From: Simon Davis
Sent: 09 April 2021 12:58
To: Planning Scanning
Subject: FW: Planning Ref: BR/81/21/CLE

Application Correspondence "Request for Amended Floor Plans"

Proposed - Ground Floor

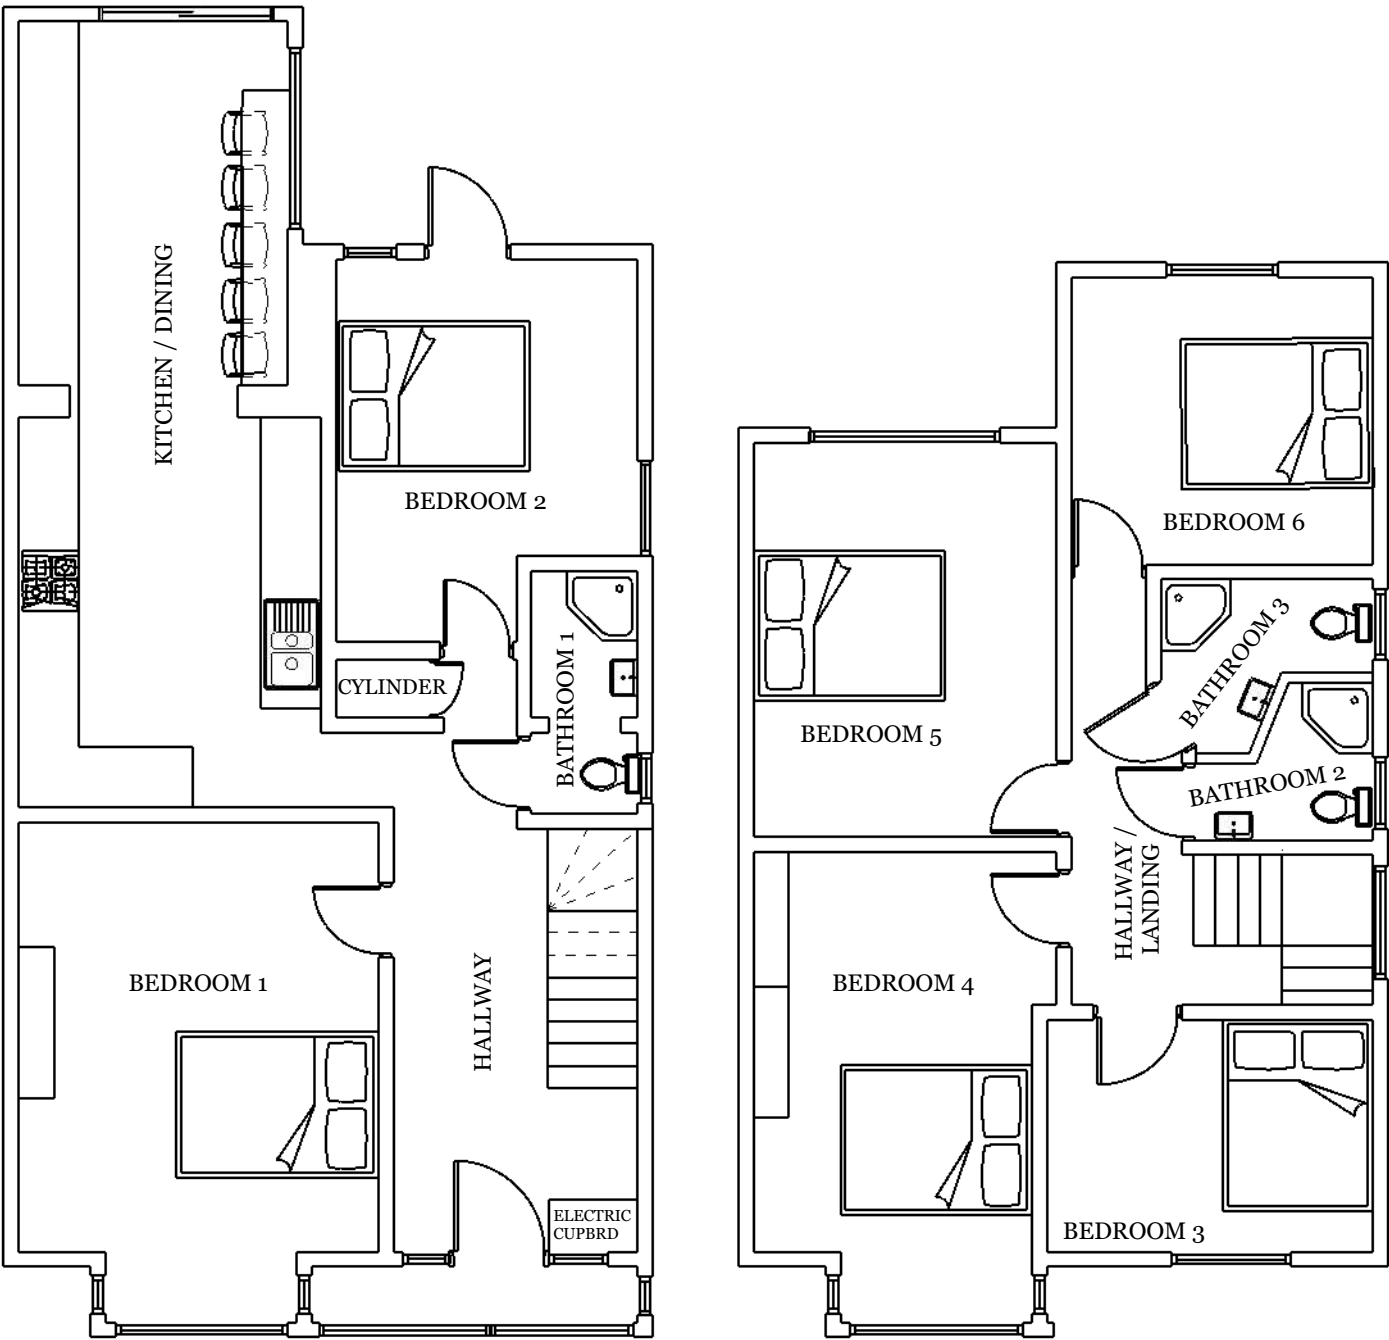
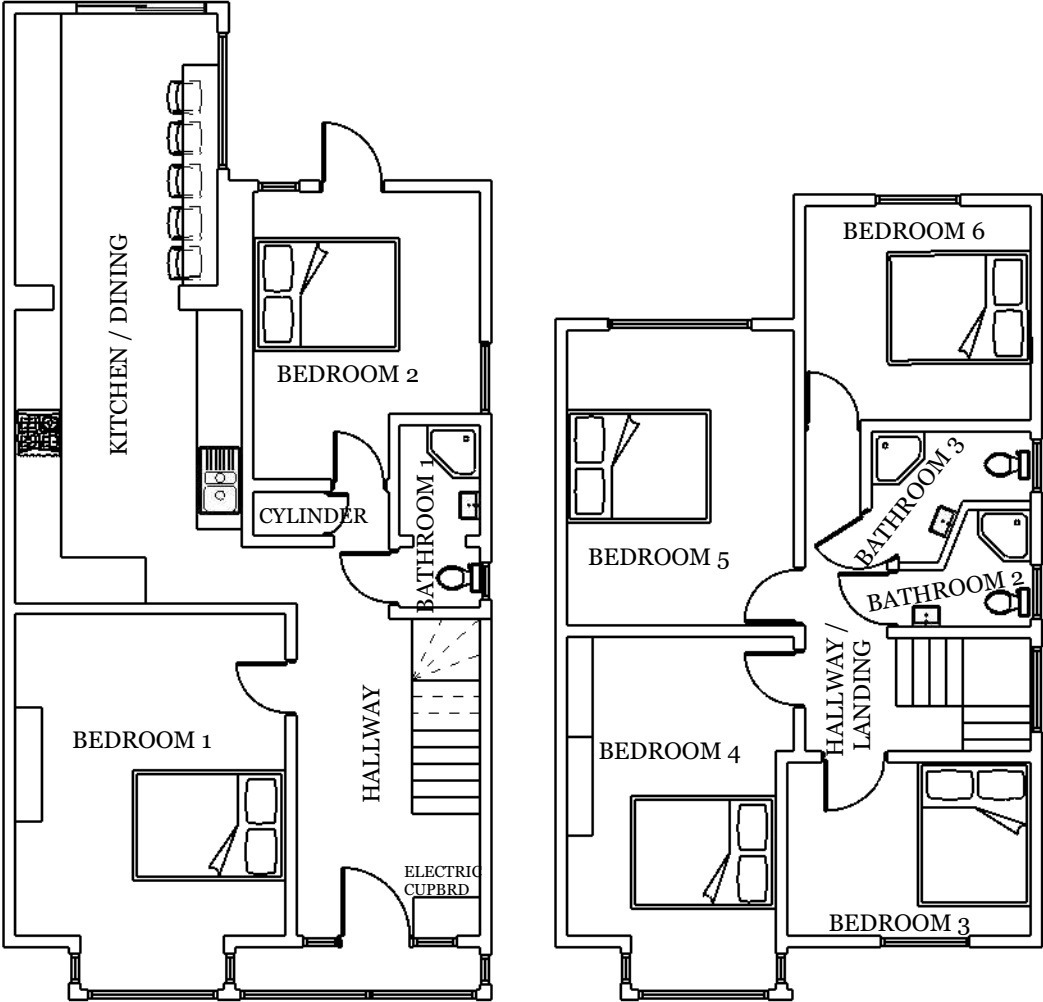
I am currently your case officer although this may yet be reallocated to an alternative officer. However, in the meantime, I have been contacted by our Environmental Health Officer (EHO) who has asked if you can confirm how many occupants you intends to have as tenants in this property please? We note that the application is for a 6 bedroom HMO but the floorplans also appear to show double beds in all rooms. The EHO also asks that you provide room sizes in m2.

Please also note that our system does not allow us to electronically scale from 1:75 plans. Those in the following screenshot are the only options we have. Would it be possible to provide a new floorplan in a different scale and then also annotate/provide a key with the room sizes.
